Portishead Branch Line (MetroWest Phase 1)

9.28 ExA.FI.D4.V1 – Appendix 5 to Application for Non-Material Change to draft Development Consent Order

The Portishead Branch Line (MetroWest Phase 1) Order

District level Licencing – consequential amendments arising from removal of Works from Schedule of Authorised Works

Drawing: EASTON-IN-GORDANO FLOOD MITIGATION PLAN

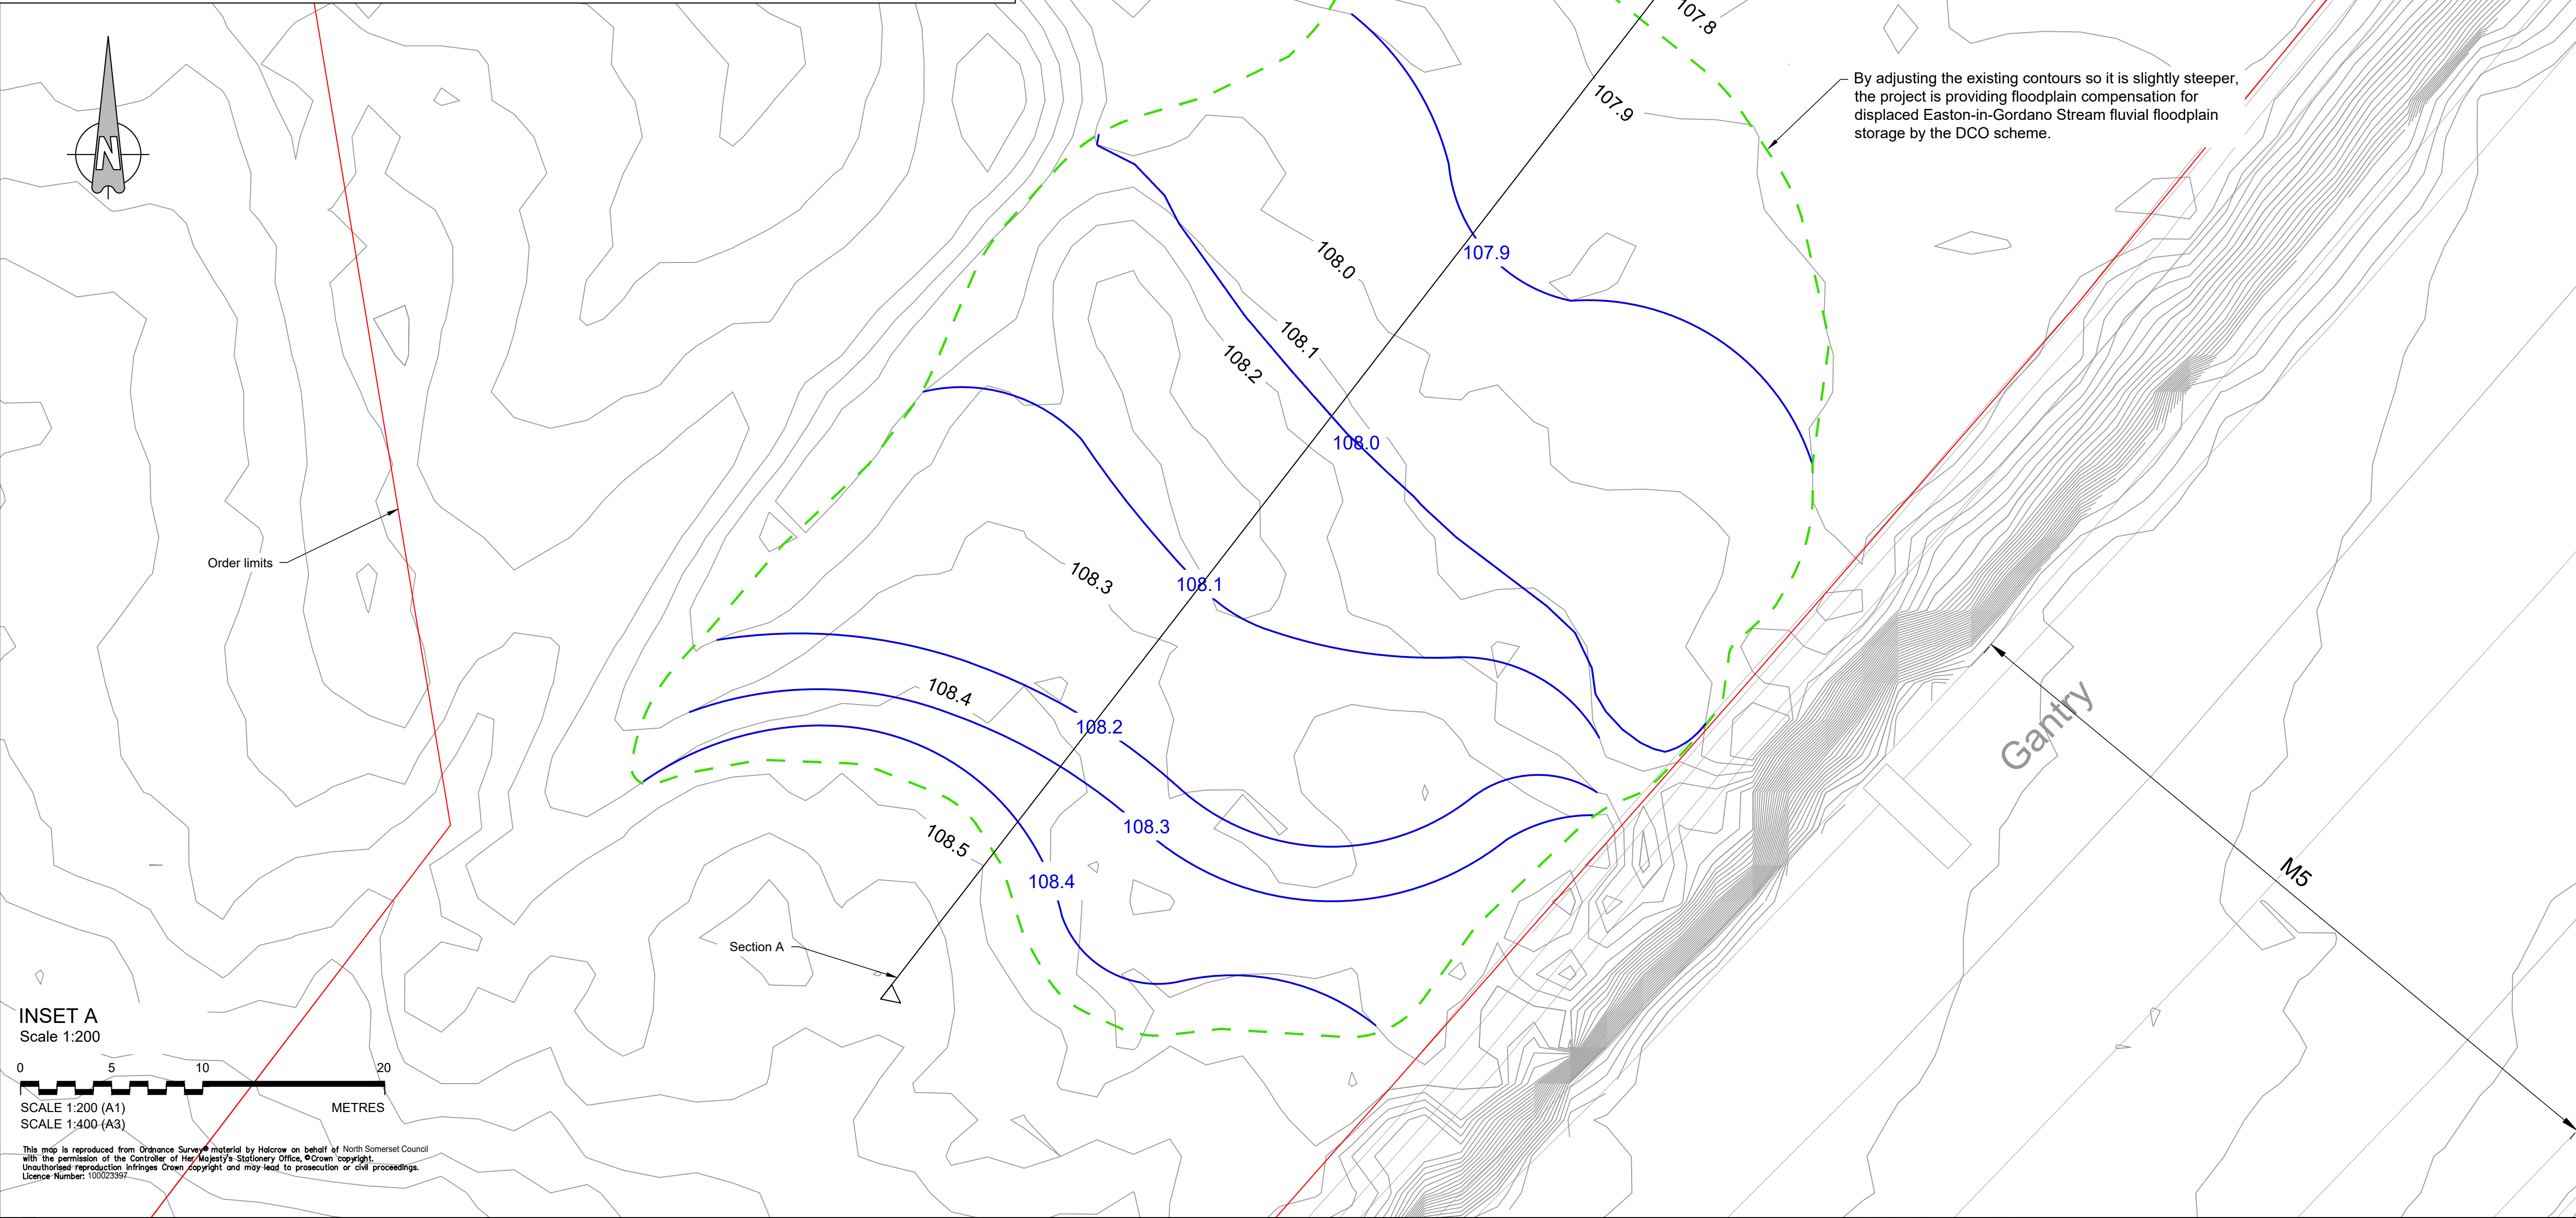
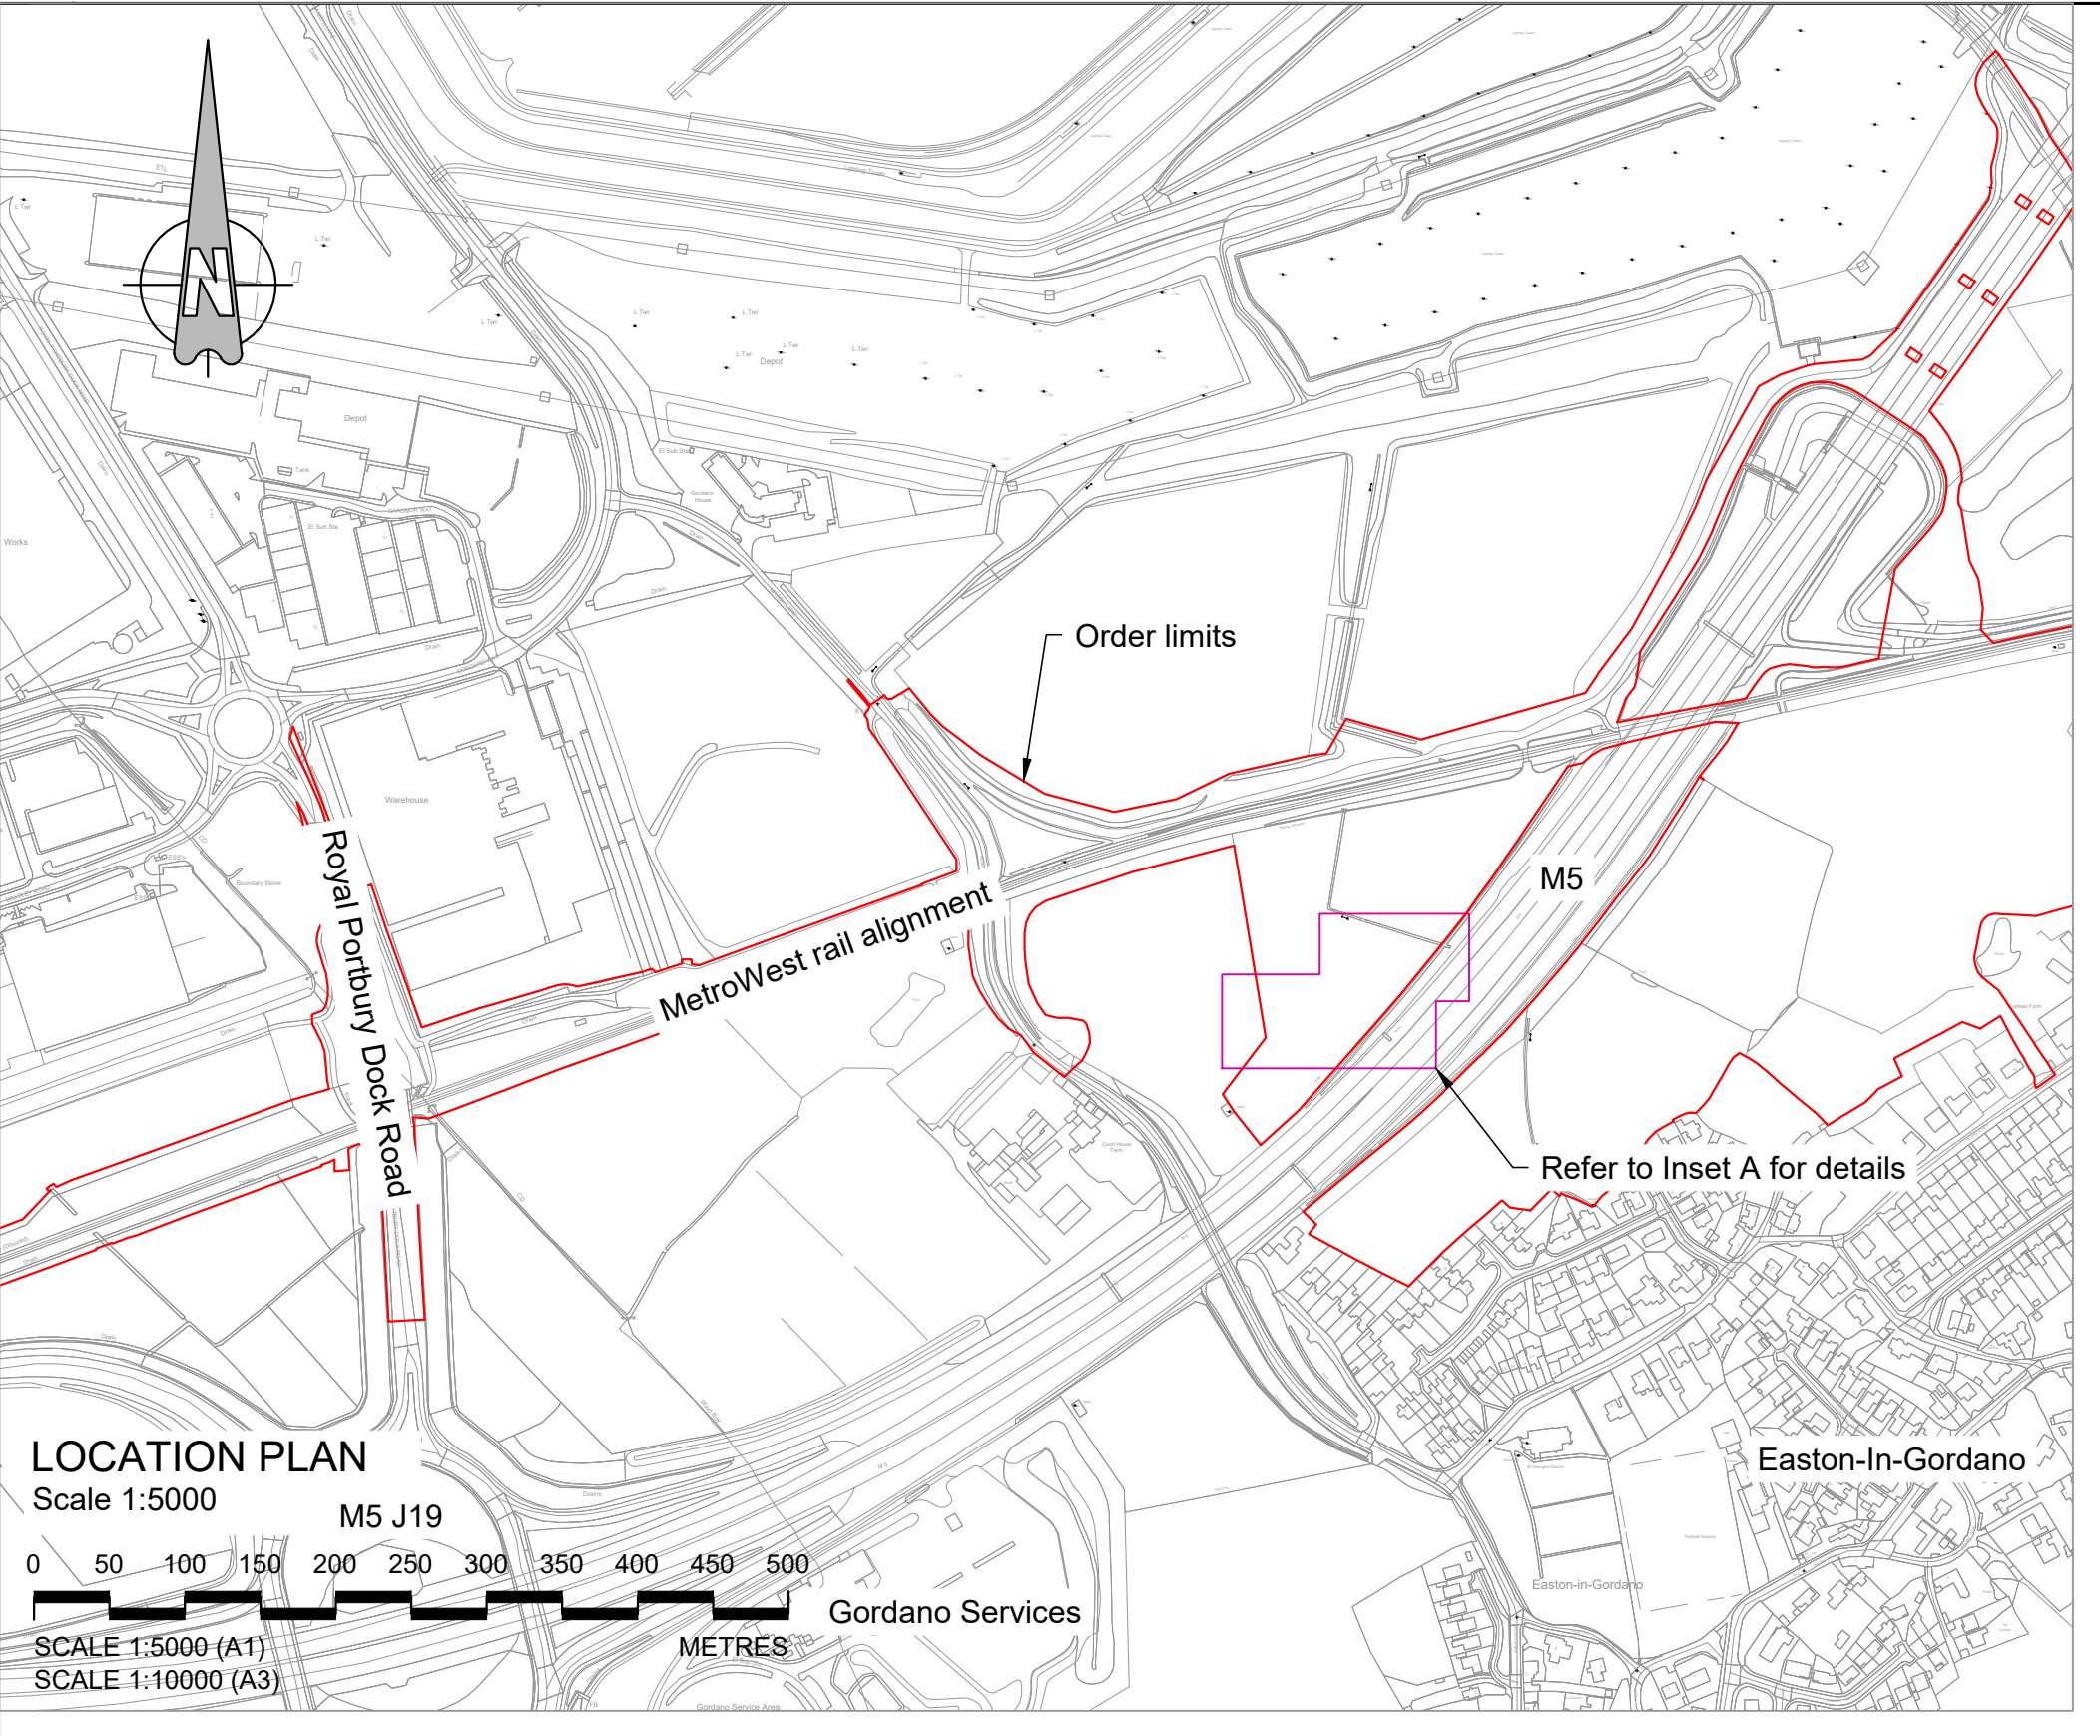
Document	Specific part of document	Changes required	
Works Plans			
- Works Plan Sheet 5	References to Work Nos. 16B Pond and 16D Easton-in-Gordano Flood Mitigation	These will need to be amended so that the references to Work No. 16B Pond and 16D Work No. 16D Easton-in-Gordano Flood Mitigation work is removed	
Environmental Masterplan	•		
Sheet 4		Needs to be updated to reflect the removal of pond. The area will be retained for other ecological mitigation purposes

- Works Plan Sheet 5	References to Work Nos. 16B Pond and 16D Easton-in- Gordano Flood Mitigation	These will need to be amended so that the references to Work No. 16B Pond and 16D Work No. 16D Easton-in-Gordano Flood Mitigation work is removed
Environmental Masterplan
